Applicant: Michael Galli

Address: 37 Ica Pond Rd - Lot 11

CHECK-LIST AGAINST ZONING ORDINANCE

amendment - permit # 15-00323

1 FRONT ELEVATION
SCALE: 1/4"=1'-0"

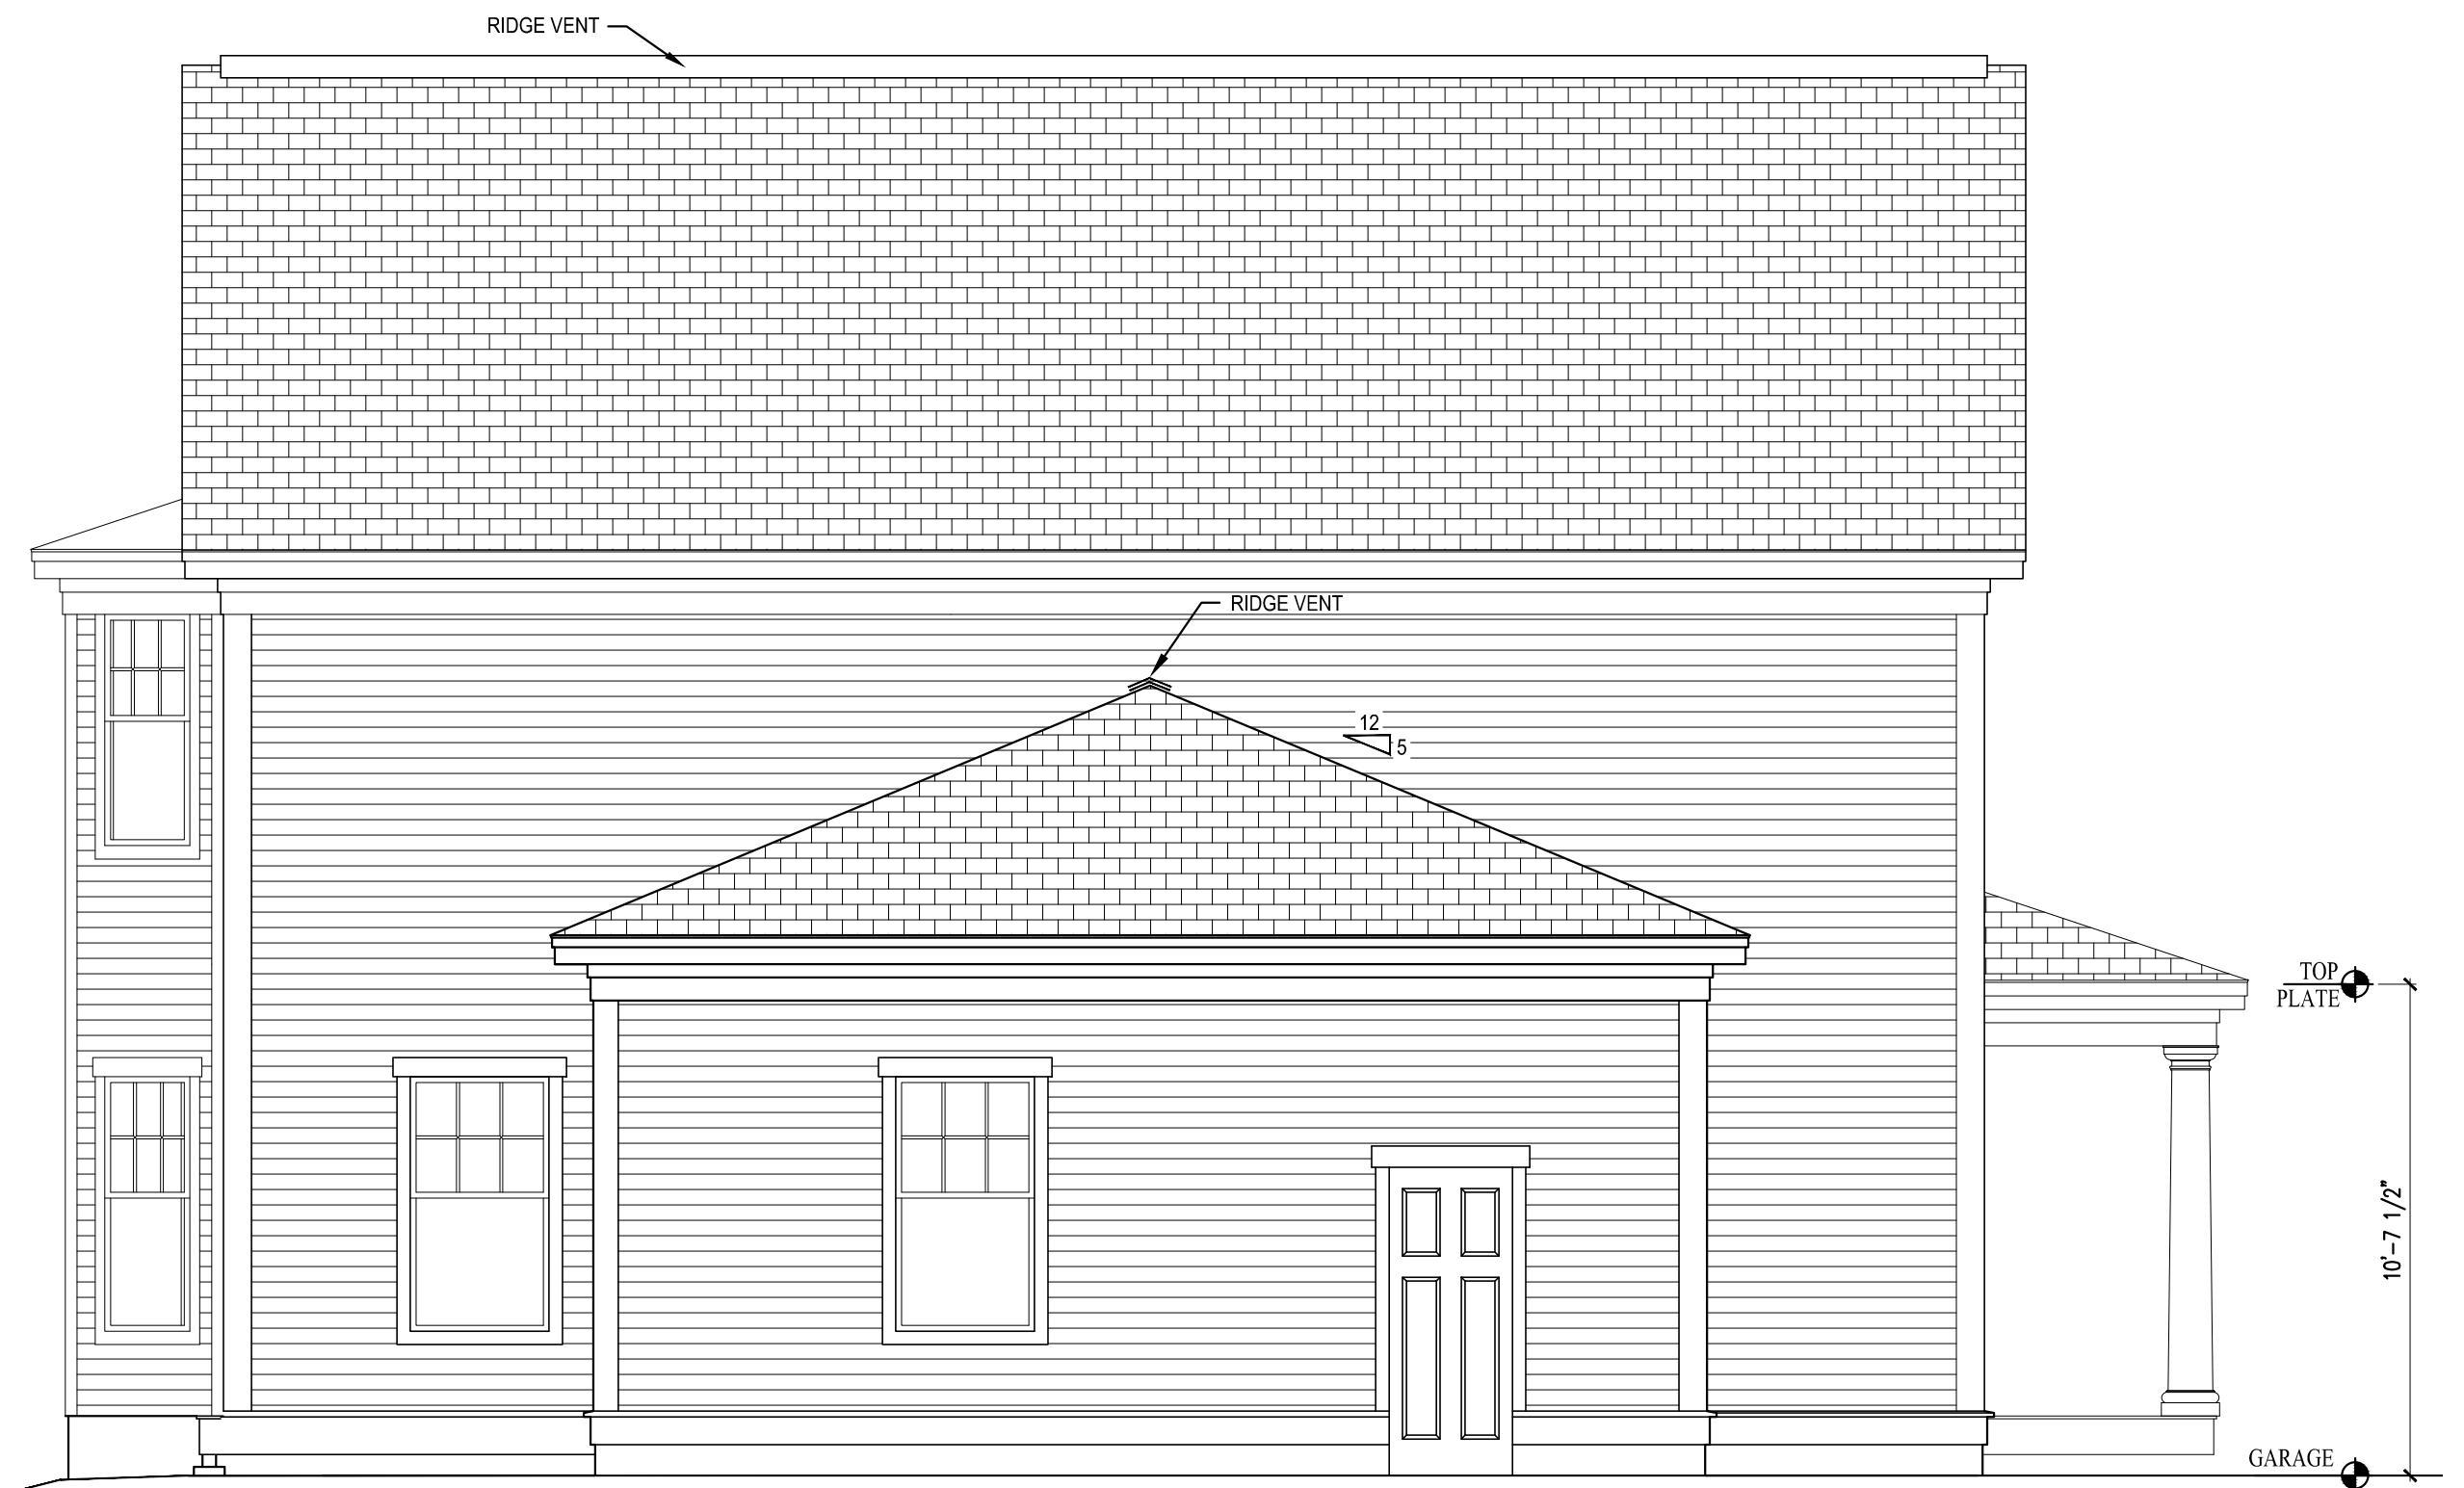
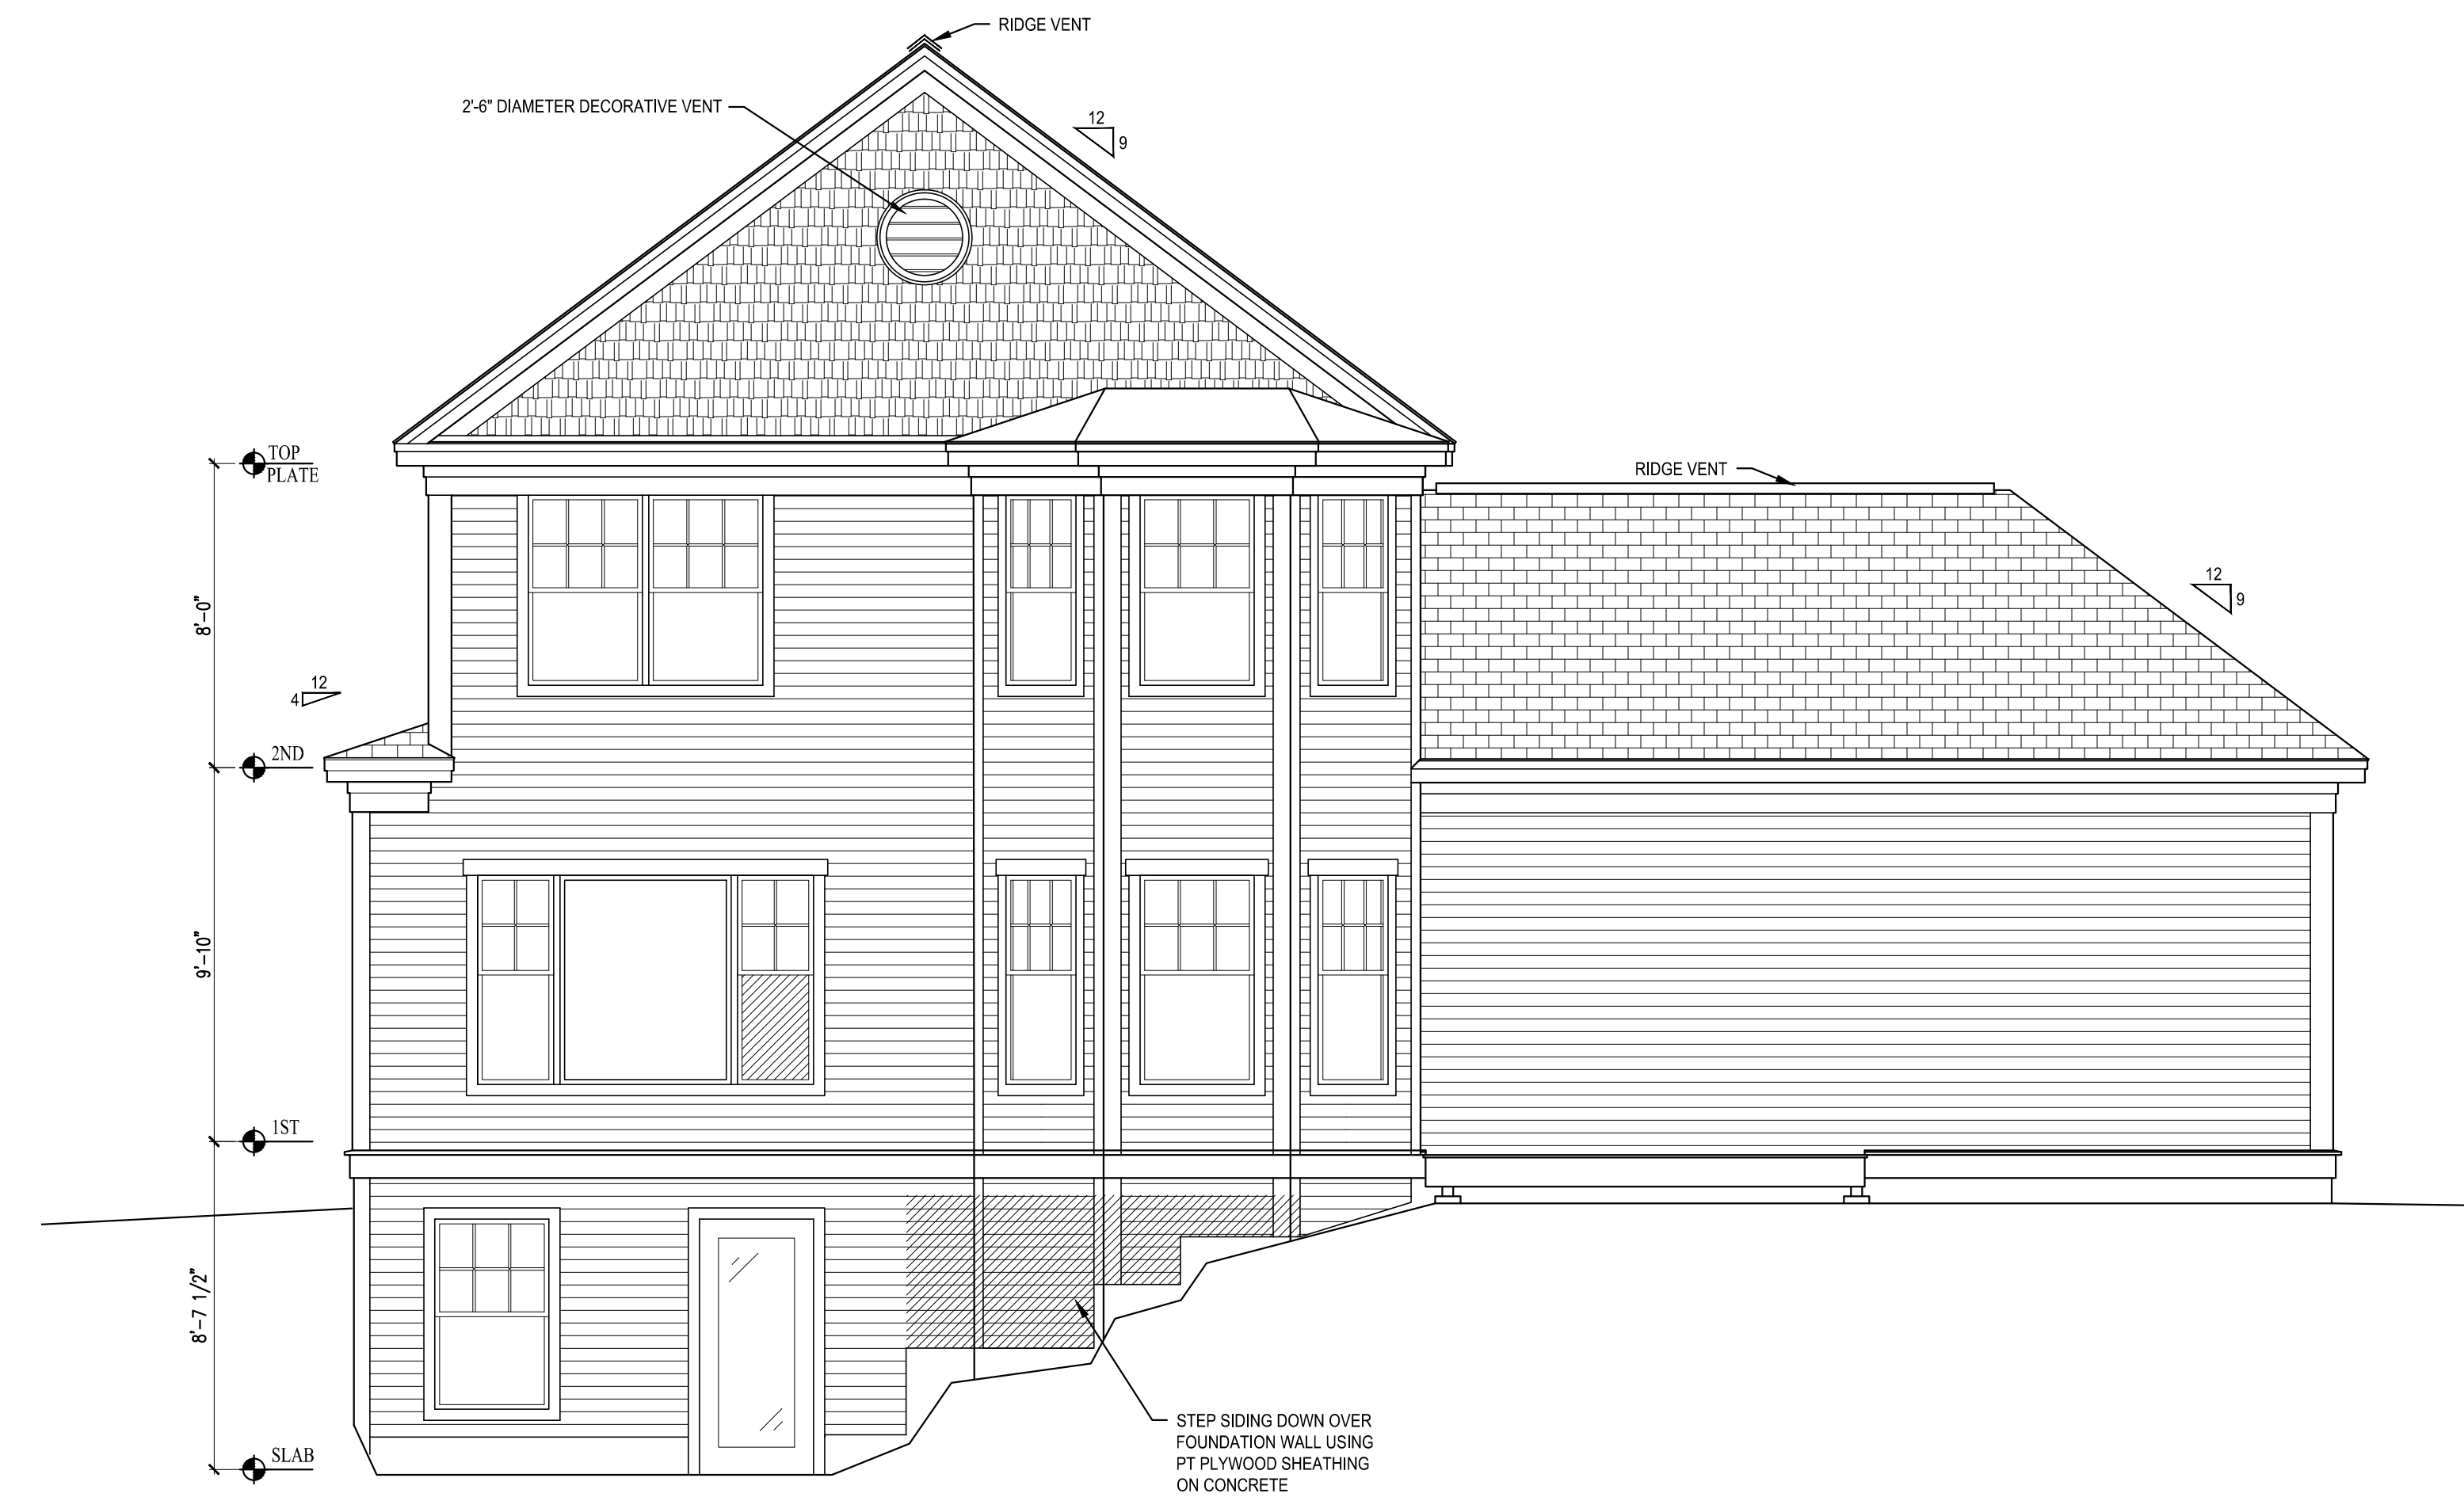
Height - 38' ~~max~~ 39' scaled to lowest grade - OK - max is 35'
